DOC21/499040
SSD 13852803 (North Sydney)

Subject: Notice of Exhibition – Sydney Metro Crows Nest OSD Site C Stage 2, (SSD 13852803)

EES has reviewed the Flood and Stormwater Assessment, Detailed State Significant Development Application, Site C, Crows Nest over station development version 1 dated April 2021.

Figure 3-2 1% AEP flood level impacts in the vicinity of Crows Nest Station.

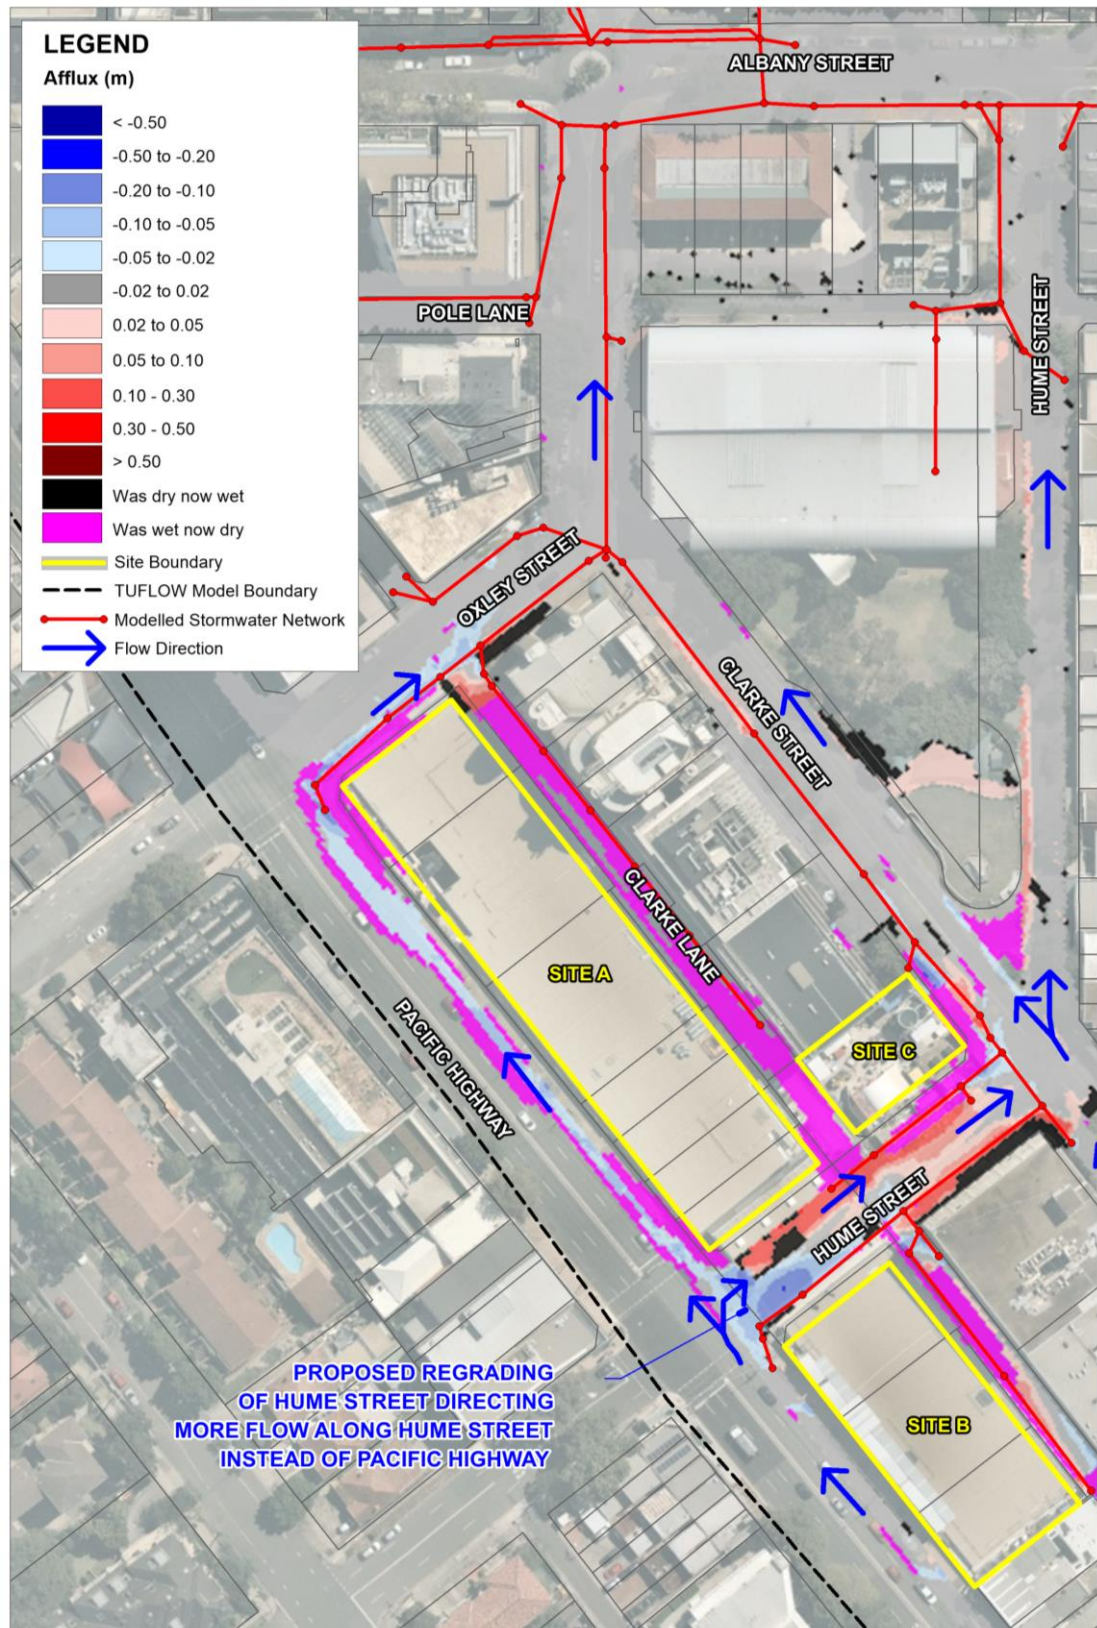
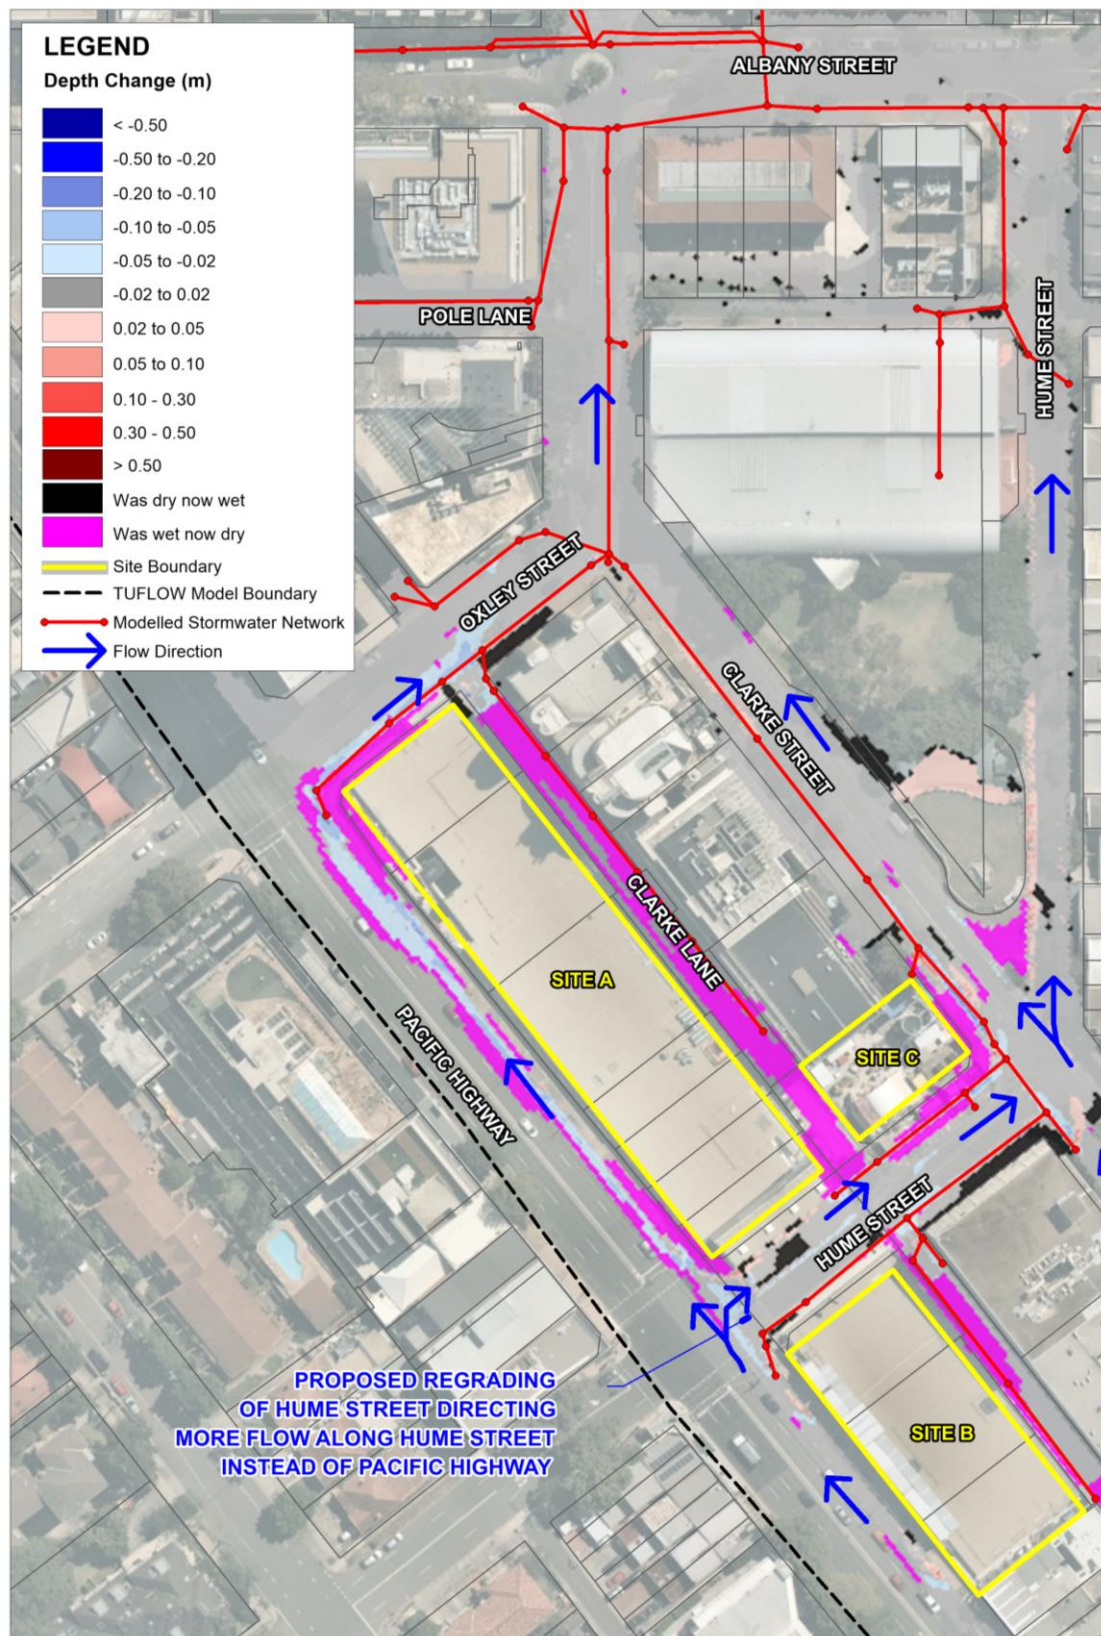
The report states that flood level impacts were not previously assessed for the OSD and shows unacceptable impacts. This is a significant departure from the Environmental Impact Statement (EIS) reporting for the Crows Nest Over Station Development, whereby no impacts were noted.

The report states that the requirement set out in "Sydney Metro – Chatswood to Sydenham SPIR REMM FH9" is for an increase in flood levels no greater than 50 mm in the 1% annual exceedance probability flood event, which is already higher than the common standard of 10 mm. The report documents several increases greater than 50 mm and therefore does not comply. Floor levels in buildings external to the project will not be raised, so the relevant criteria for external properties must remain the flood level increase and not depth increase. Depth increase may be an appropriate criterion within the footprint of the development, such as roads that will be regraded, but it is not acceptable for existing developments external to the project.

The building at 10-12 Clarke Street has commercial tenancies and a basement car park entry on Hume Street. The entries to these tenancies, including the car park entry, are at grade with the flood affected footpath.

Flooding of the basement car park may pose a significant risk to life. The development is predicted to exacerbate flooding at these tenancies and car park entry by raising flood levels 0.1 to 0.3 m. This would result in increased flood damage and potentially a greater risk to life and limb.

The development would also exacerbate flooding at Kelly's Place Children's Centre, which is considered a sensitive use. The centre caters for children 0-5 years and thus has limited evacuation capability. Modelling indicates that the outdoor play area to the north is already affected by flooding in the 1% annual exceedance probability flood event under existing conditions. These flood levels are predicted to increase by 0.02 to 0.05 m on the outdoor play area to the north of the building, and 0.05 to 0.1 m in Hume Street, to the east. Floodwater from the outdoor play area and Hume Street would likely enter the centre and necessitate evacuation. Flood levels should not be exacerbated as this would likely also lead to an increased frequency of flooding of the centre.

EES does not support the development in its current form without addressing the above issues, for example through:

- revision of design to reduce flood impacts to acceptable levels
- detailed assessment of flood level impacts at building entries, which could include local mitigation measures or compensation and
- consideration of the volumes of water entering underground car parks to determine the significance of impacts.

It would be prudent to add a similar detailed assessment for 28-34 Clarke Street, which is also noted as being adversely affected. The report notes that floor levels would not be affected but does not address the whether there is a significant reduction in freeboard nor whether service openings are affected.

The report notes that velocities are increased across large areas. Given the increases in velocity and depth, it would be prudent to assess whether there is an increase in the provisional flood hazard category (H1-H6) to ensure the risk to pedestrians and stationary and moving vehicles is not increased as a result of the project.

Figure 3-4 OSD Entries and Egresses to the underground Crows Nest station.

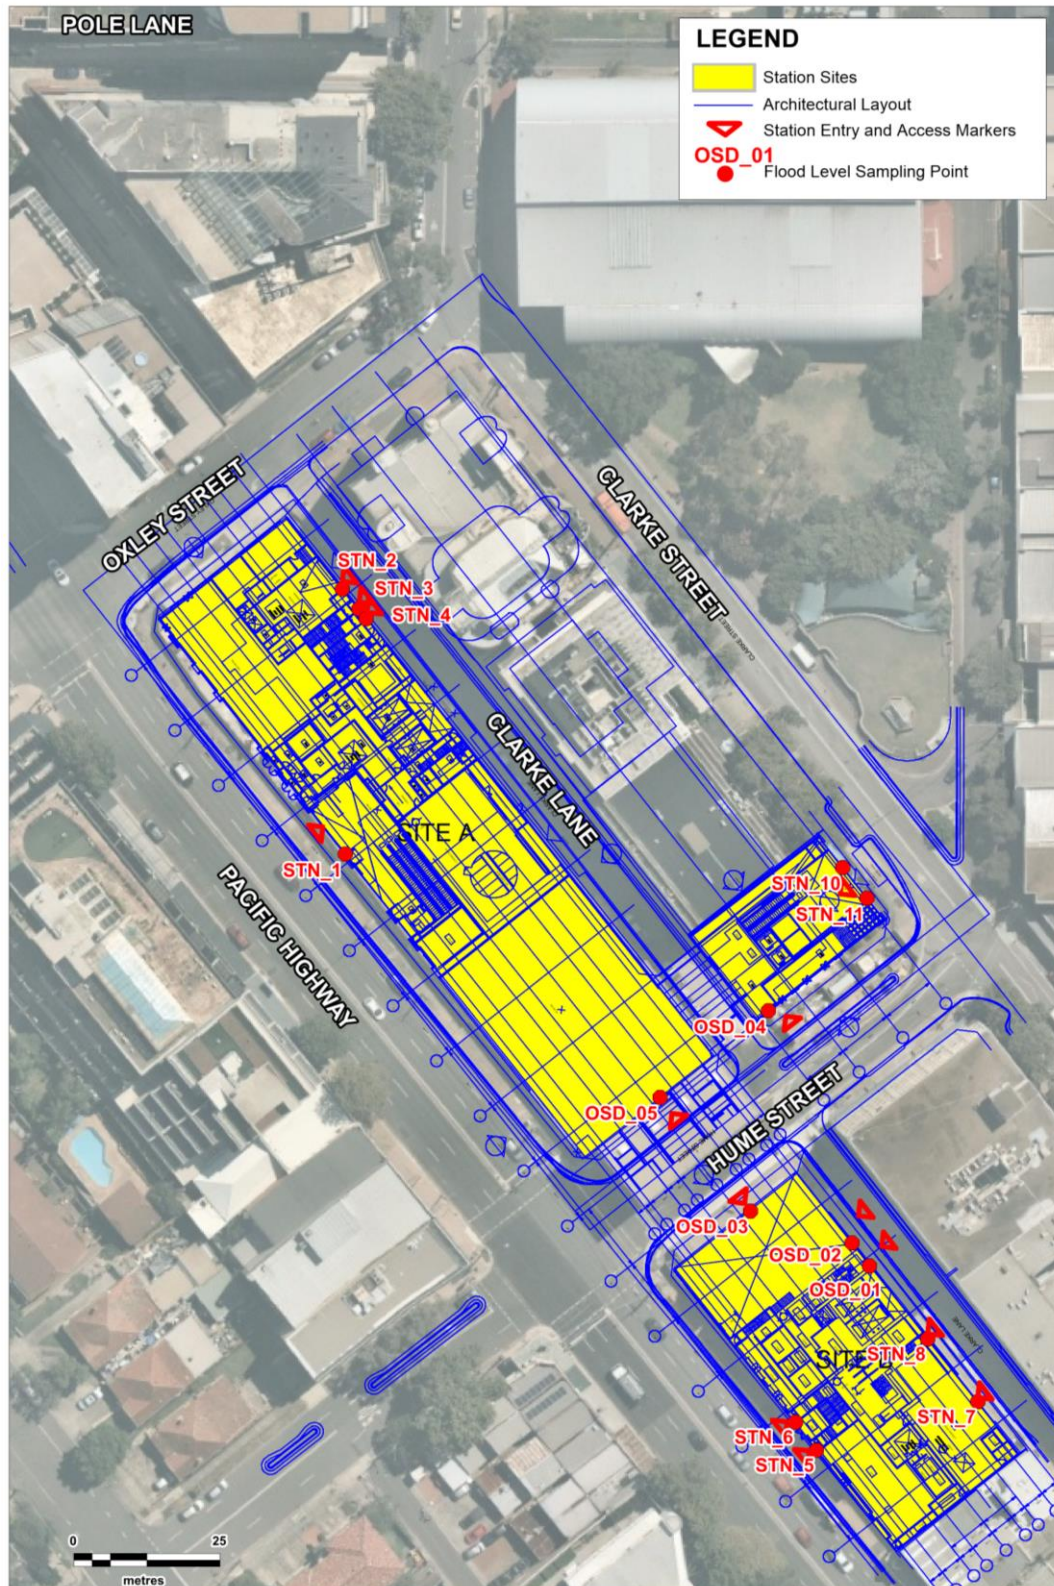
The report for Site C documents two entrances that lead to underground rail infrastructure and a further entrance for the over station development. The EIS stated that station entrances would be 500 mm above 1% annual exceedance probability flood levels. However, a freeboard of 300 mm would not be unreasonable where there are low depths of flooding. The station entrances must also be above the probable maximum flood level.

Both entrances that lead to underground rail infrastructure may not have sufficient freeboard to the 1% annual exceedance probability flood levels. These levels have not been documented in the report.

For the over station development, the floor level at the water meter and gas meter room should be documented to ensure this is above the relevant 1% annual exceedance probability flood level as a minimum. The same applies for the electricity meter room, which appears to be housed in a fire stair.

Tables 3-2 and 3-3 in the report should be revised to include the additional entry points, the 1% annual exceedance probability flood levels and corresponding freeboard available at each entrance, or where relevant, the level beyond any internal step.
